Meeting note

Project name	M5 Junction 10 Improvements Scheme
File reference	TR010063
Status	Final
Author	The Planning Inspectorate
Date	28 November 2023
Meeting with	Gloucestershire County Council
Venue	Microsoft Teams
Meeting objectives	Project Update Meeting
Circulation	All attendees

Planning Act 2008 (as amended) – Section 51

Application by Gloucestershire County Council for an Order Granting Development Consent for the M5 Junction 10 Improvements Scheme

Figure 2.1- M5 J10 Designated Diversion Routes

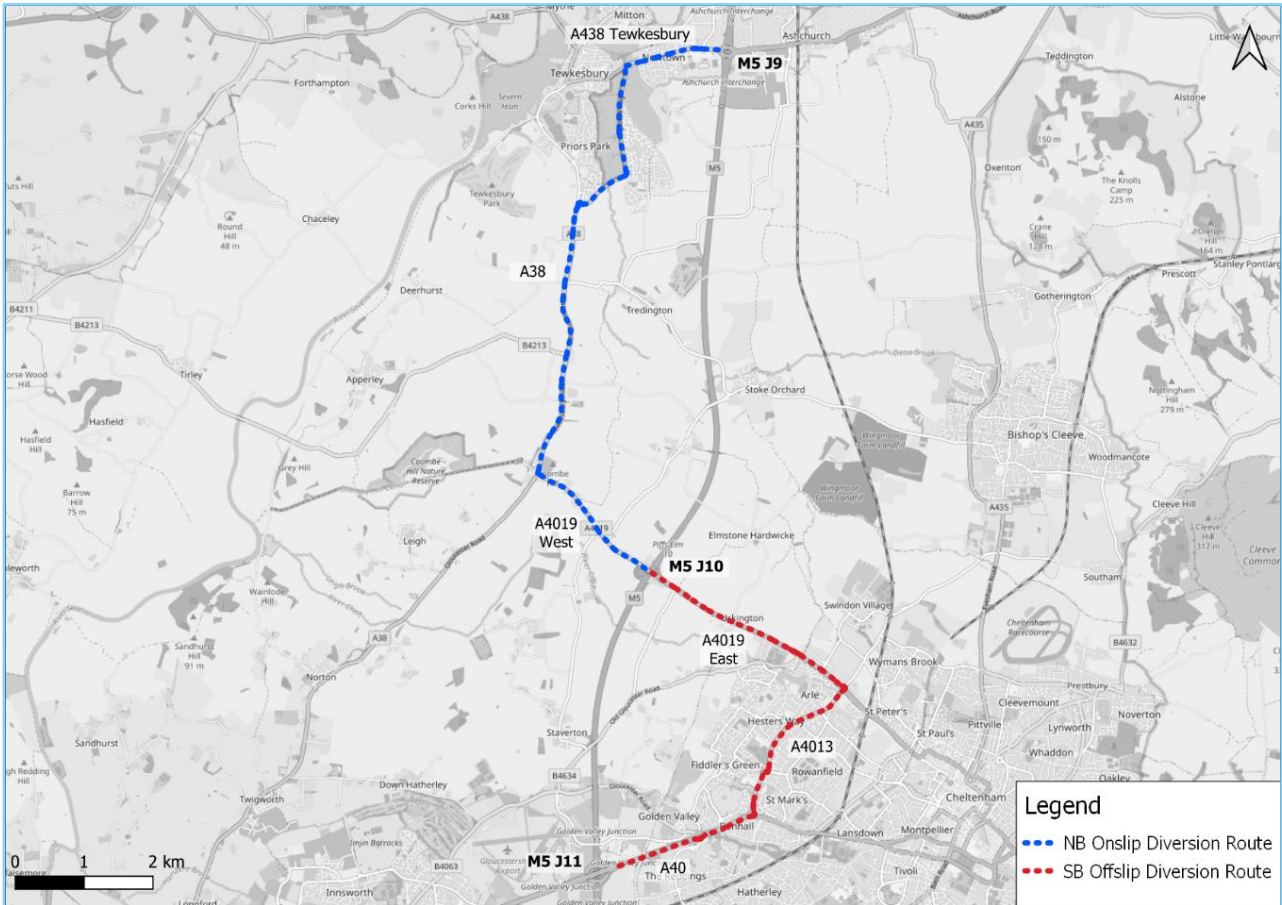
Information on traffic diversion routes during construction as a result of closures to the M5 Junction 10 slip roads has not been included in the Environmental Statement (ES). It is therefore unclear whether there would be any likely significant effects on sensitive receptors located on diversion routes that could be affected by changes in traffic, for example due to noise impacts, effects on local communities and users of local roads, and whether such effects would require mitigation.

The Applicant should provide information in the ES to describe the likely traffic diversion routes required during construction, with reference to their nature, scale and duration. It should provide an assessment of effects to sensitive receptors, where likely significant effects could occur or otherwise explain, with reference to relevant guidance, why significant effects would not occur. For the avoidance of doubt, this should include consideration of noise and impacts on local communities and road users. The ES should set out any measures required to mitigate significant effects identified. The Applicant should ensure all relevant assessments influenced by the traffic diversions are included.

Following on from the s51 advice, the Applicant is proposing to provide information on any likely significant effects that may occur as a result of traffic changes across the network due to the closure of the existing two M5 slip roads during construction. They will include a figure depicting the proposed diversion routes and provide additional information in the relevant ES chapters.

In respect of diversion routes, the Applicant confirmed it will assess the increase in noise against a threshold of 3dB and identify whether further sensitive receptors would be subject to likely significant effects. Information is to be included in the ES.
